Re: Sawmill Bldg J
800 20th St NW
Traffic Circulation Layout
Engineer's/Architect's Stamp 9-30-24 (J13D076B)

Based upon the information provided in your submittal received 10-1-24, the above referenced plan cannot be approved for Building Permit until the following comments are addressed:

PARKING LAYOUT (1FL)

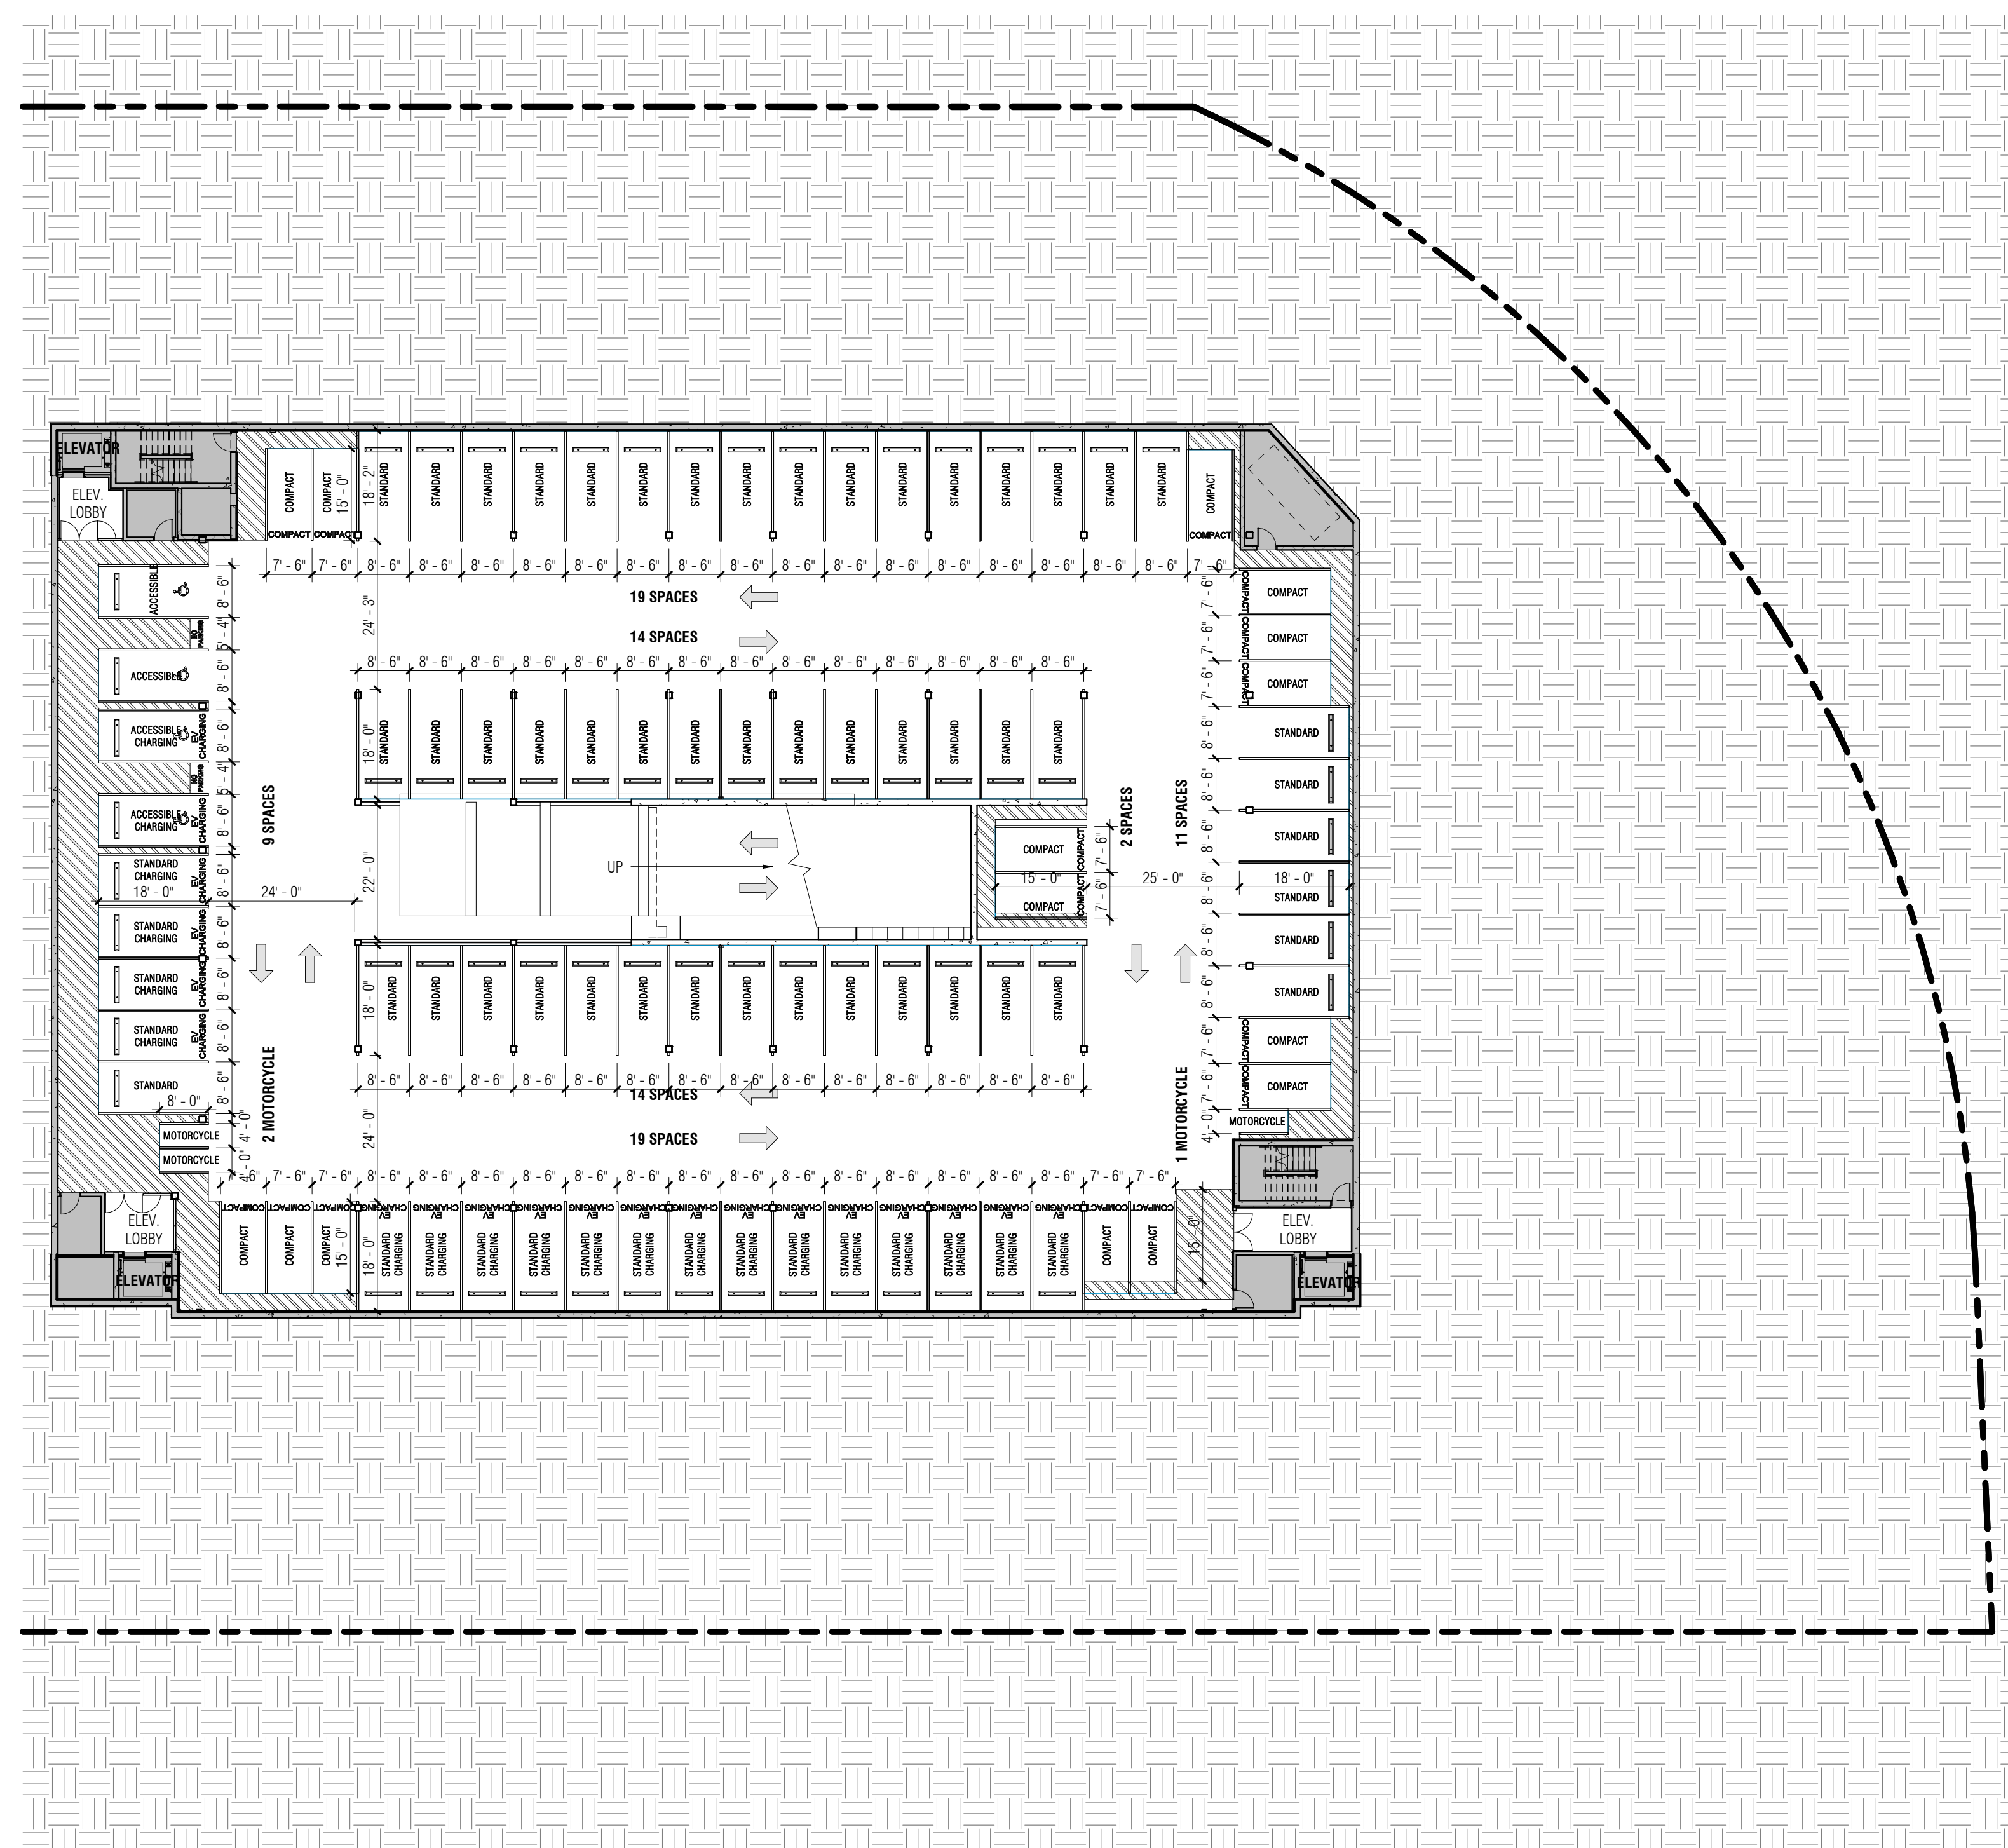
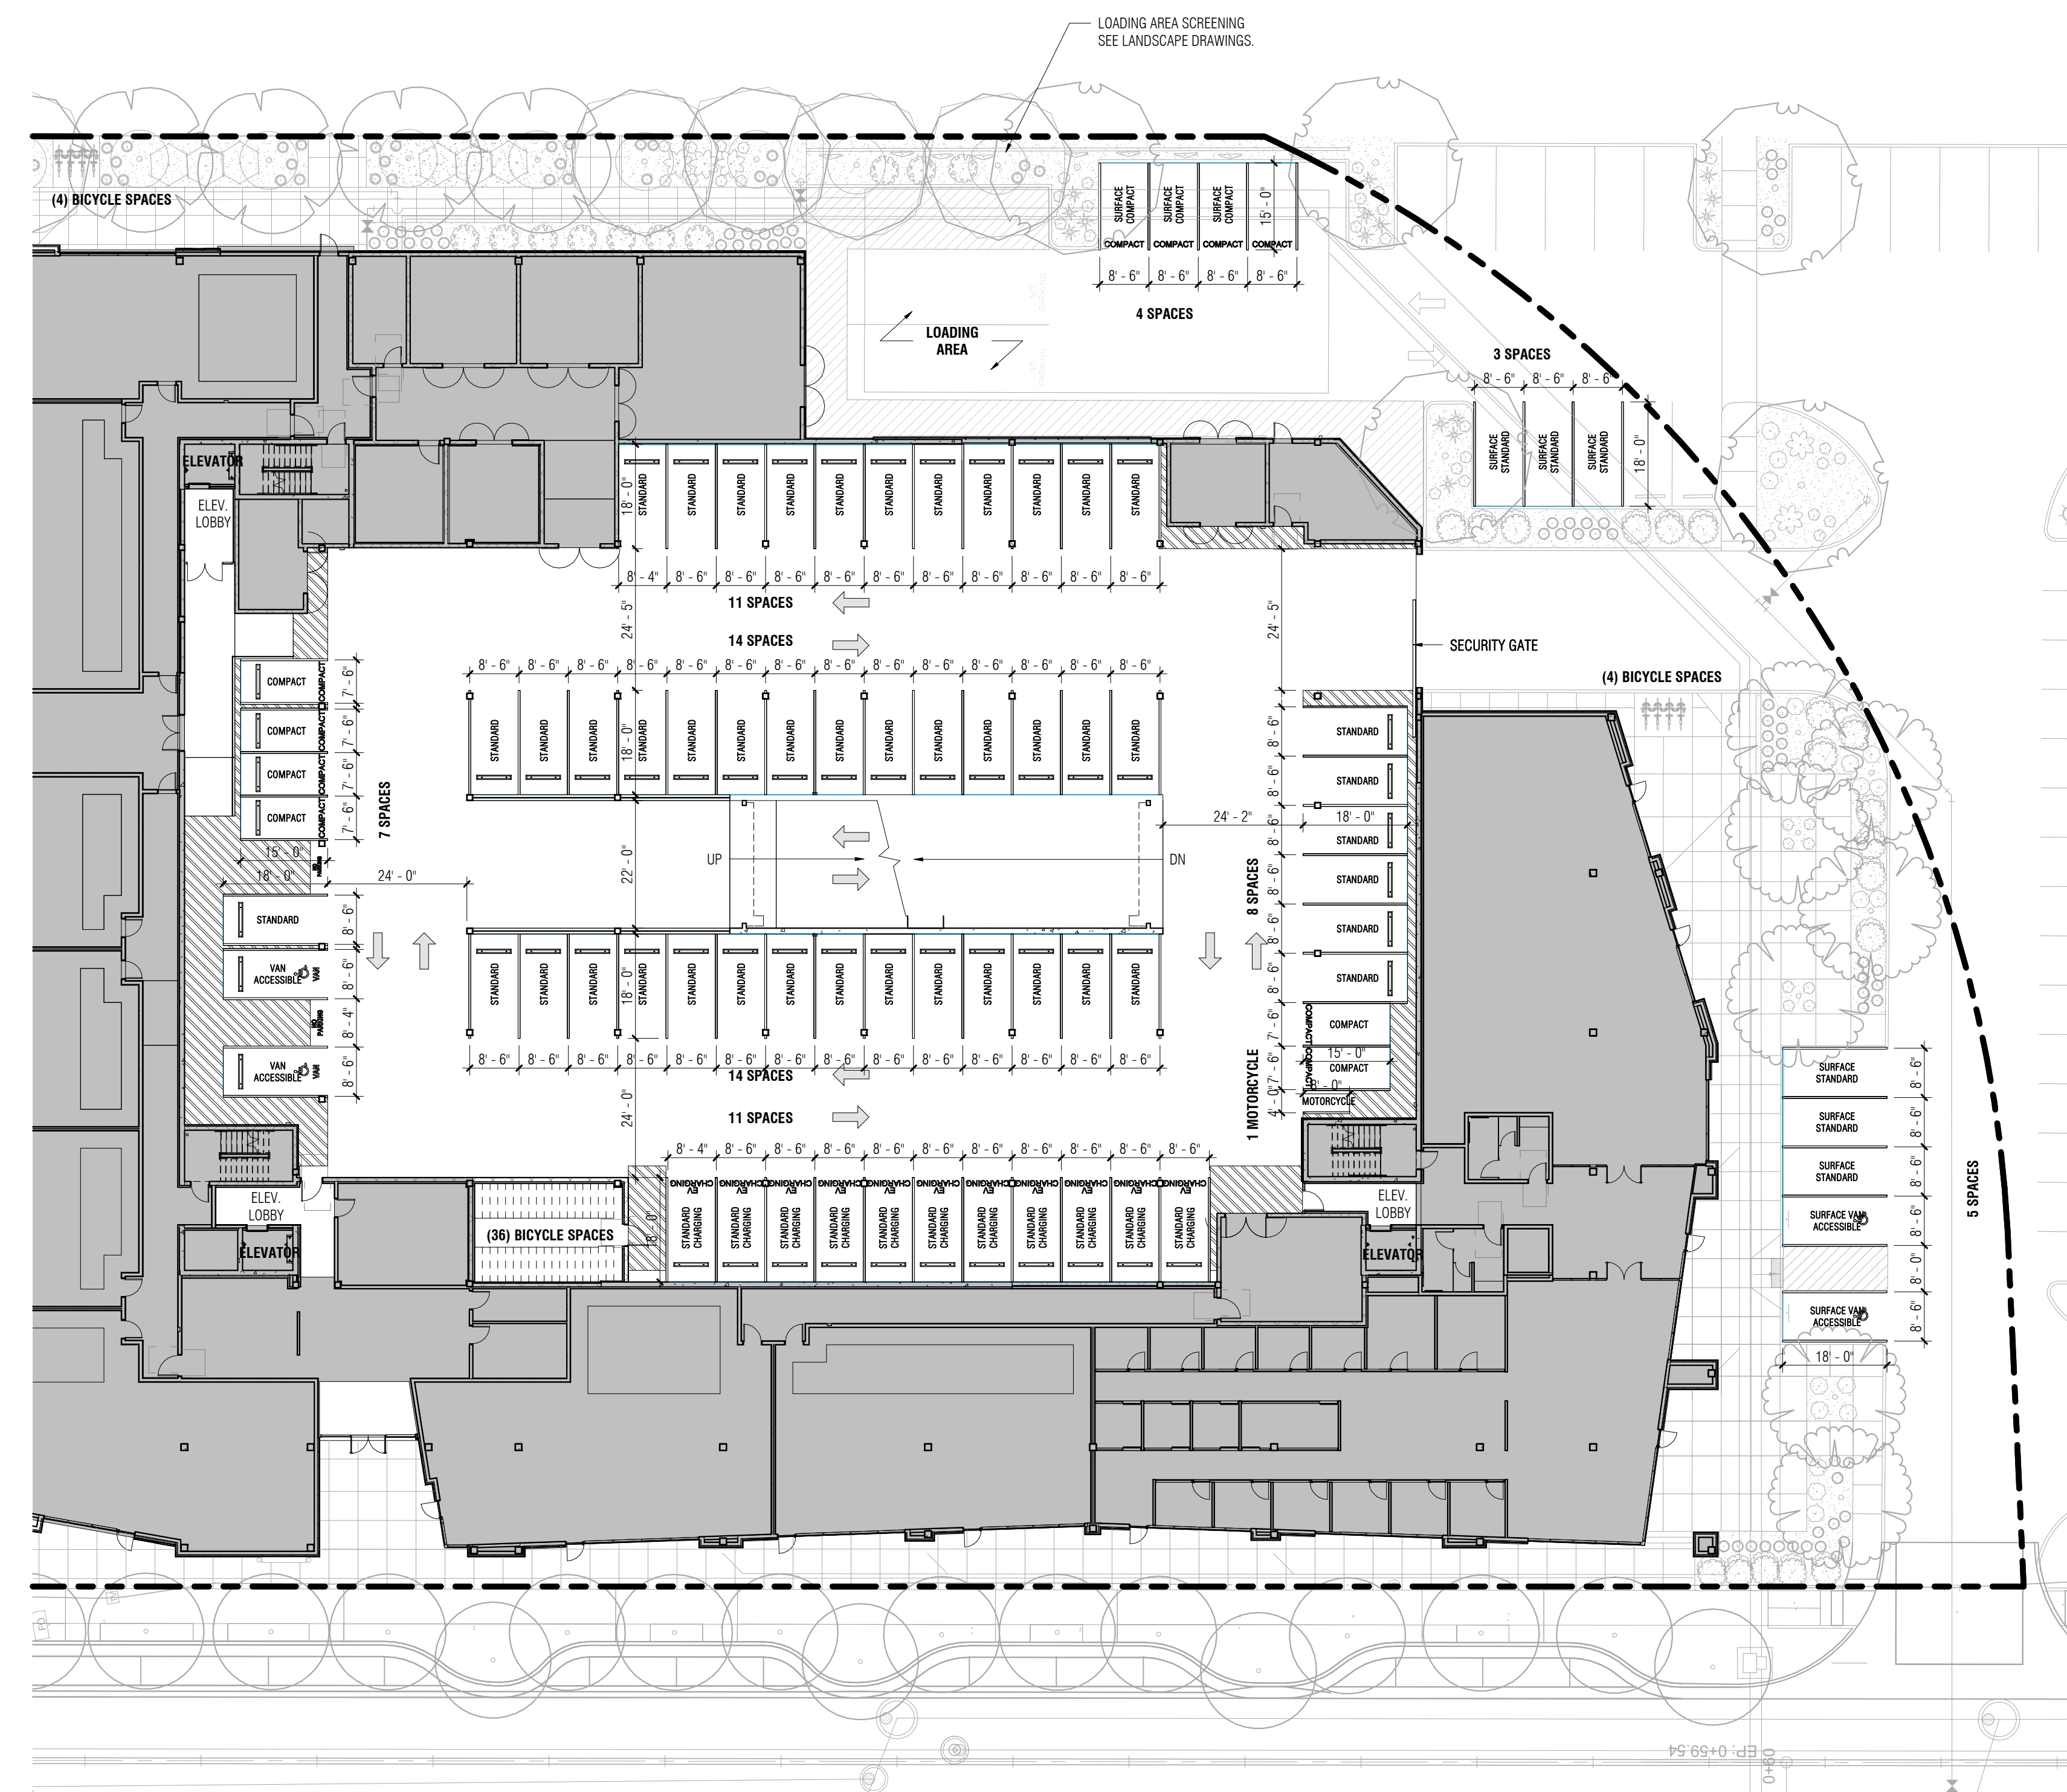
1. Show detailed calculations of the number of parking spaces required by the IDO as well as the proposed number of parking spaces including bicycle and motorcycle parking. Specify the area sqft for each type of use and required parking spaces. Also, specify the details of Multi-family Dwelling (# of BRs). Specify details for % reductions in parking spaces.

2. Please list the width and length for all existing and proposed parking spaces. Some dimensions are not shown. Identify the texts on parking stall (S, SS, SC, C). There are 11 EV spaces on the plan, but the table indicates 50 spaces?

3. Label the compact parking spaces by placing the words "**COMPACT**" on the pavement of each space.
4. ADA curb ramps must be updated to current standards and have truncated domes installed.
